CITY OF ALBUQUERQUE

RE: Building A1 Sawmill Village
1771 Bellamah Ave. NW
Permanent Certificate of Occupancy – Approved
Grading and Drainage Plan Stamp Date: 7/31/17
Certification Date: 12/3/21
Hydrology File: H13D025C

GRADING PLAN

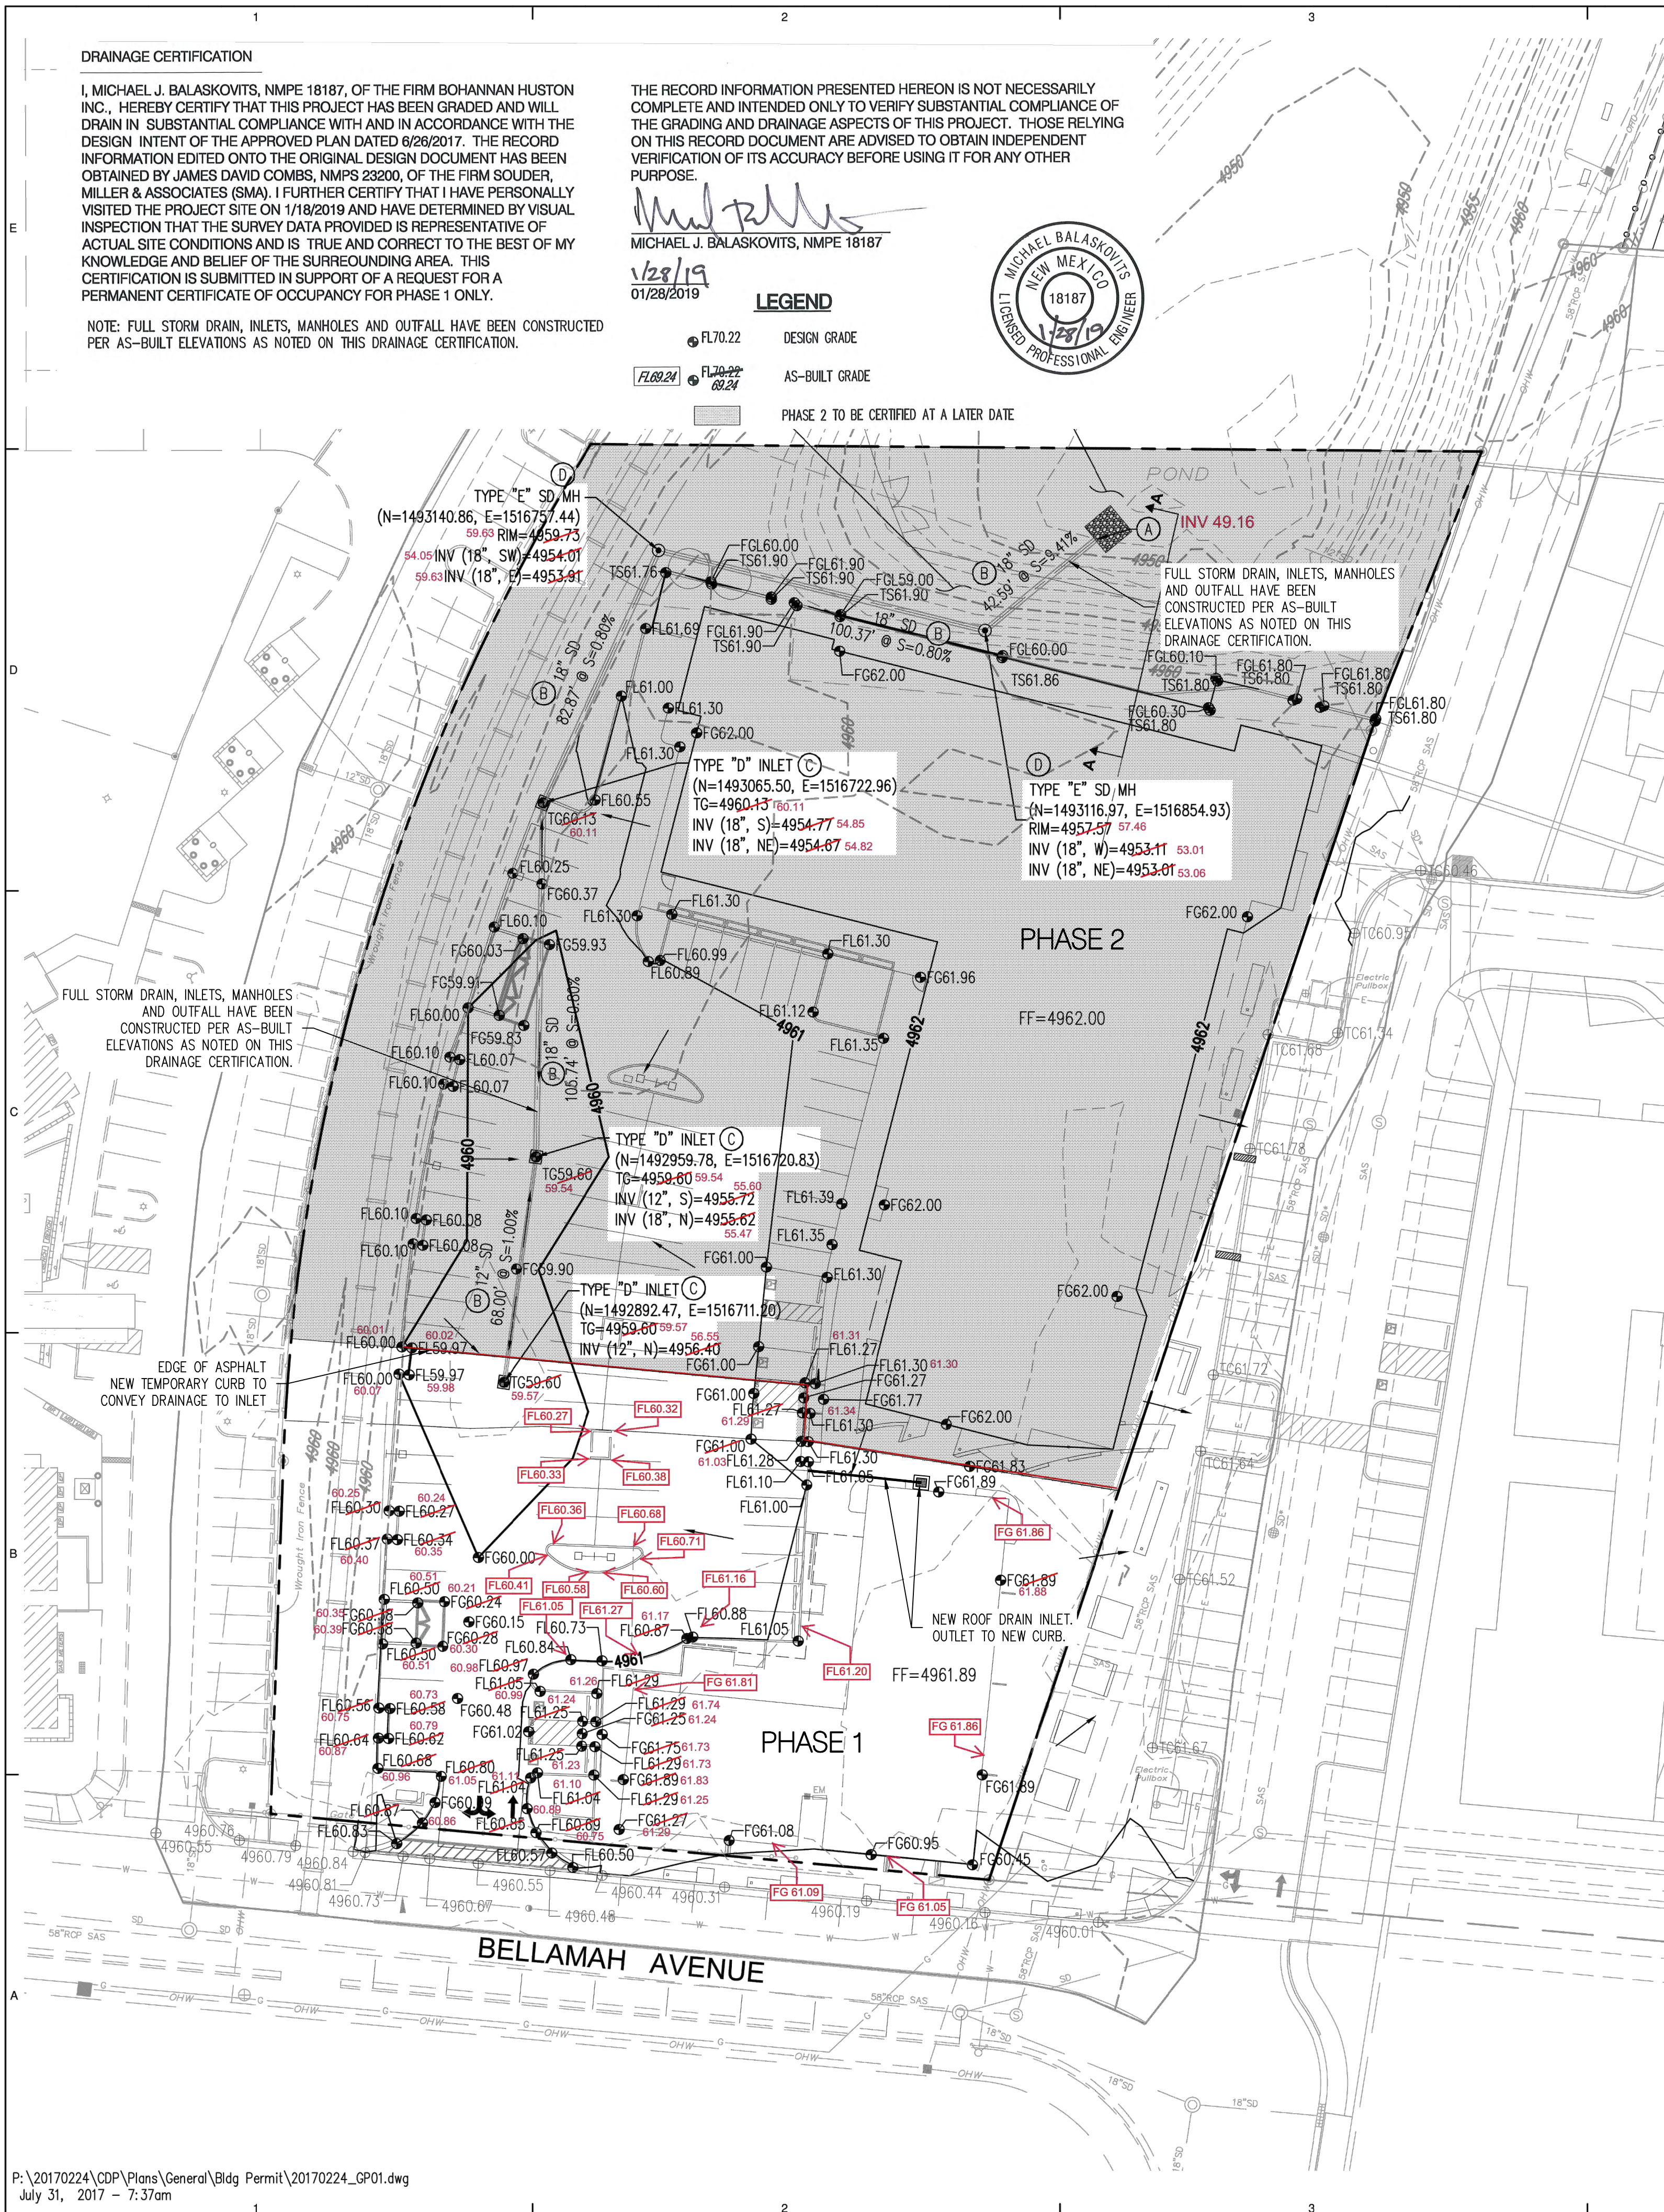
Please have your contractor check the storm inlets in the parking area. The northern one has a piece of filter fabric attached under the grate, possibly as part of the SWPP. Please have it removed.
